RE: Proposed Warehouse and Logistics Hub, 5 and 9 Culverston Road, Minto (SSD 7500)  
Response to Submissions

Ason Group has been commissioned by Tactical Group to provide traffic, transport and parking advice in support of a State Significant Development Application (SSDA) to the NSW Department of Planning & Environment (DPE) for a proposed warehouse and logistics hub (the Proposal). The subject site for the Proposal is located at 5 and 9 Culverston Road, Minto (the Site). As part of the SSDA submission, a Traffic Impact Assessment (TIA) report titled *Proposed Warehouse Development 5 & 9 Culverston Road, Minto* dated 27 April 2016 (ref: 0191r01v2) was prepared by Ason Group (the 2016 TIA report).

Drawing Title
WAREHOUSE 1B - SITE PLAN
Drawing Number
116101_A_SSD_A2001
Sheet
2

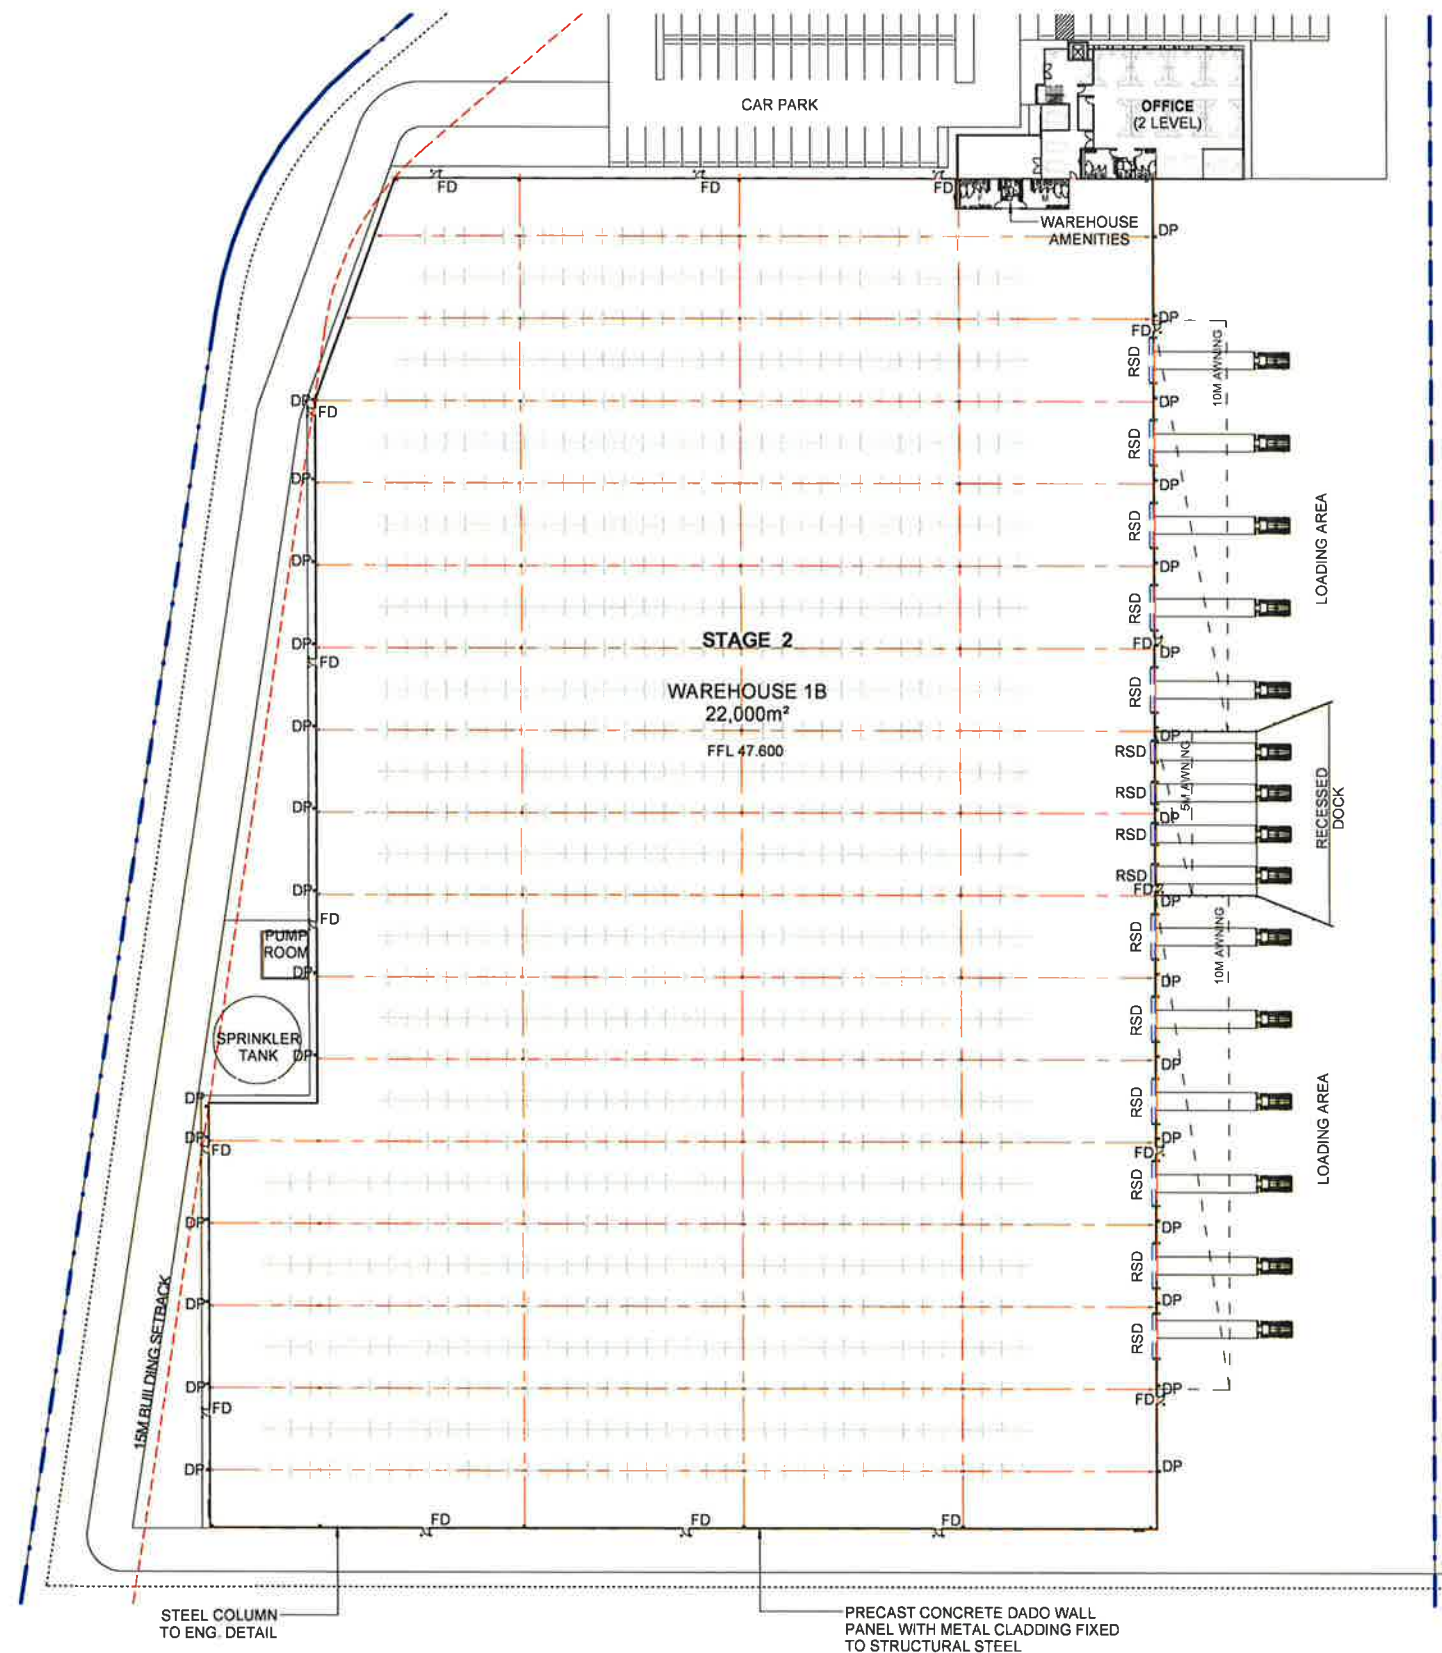
*All vehicle swept path analysis shall be undertaken using the longest design vehicle to access the site. All truck entries shall be designed in order to accommodate the opposing swept paths of the longest vehicle turning safely at the same time. In this regard, it is considered that for warehouses of the size proposed, B-double vehicles would be highly likely to use the site. Accordingly, a swept path analysis for full size B-doubles is required to be submitted to Council, to demonstrate that B-double combination vehicles will be able to access the site, manoeuvre satisfactorily, and safely leave the site in a forward direction.*

Concurrent B-Double access is not provided in the current design for Warehouses 1B, 1C and 1D as this would require excessive driveway widths which is considered undesirable due to the impact on the frontage. This is considered acceptable under AS2890.2 Clause 3.2.4 (b), which states “*The swept path of the maximum size design vehicle using the facility may be allowed to occupy the entire width (less specified clearances) of a two-way access driveway when the vehicle is entering or leaving the minor road*”. In this regard, **Attachment 1** details B-Double access to all warehouses.
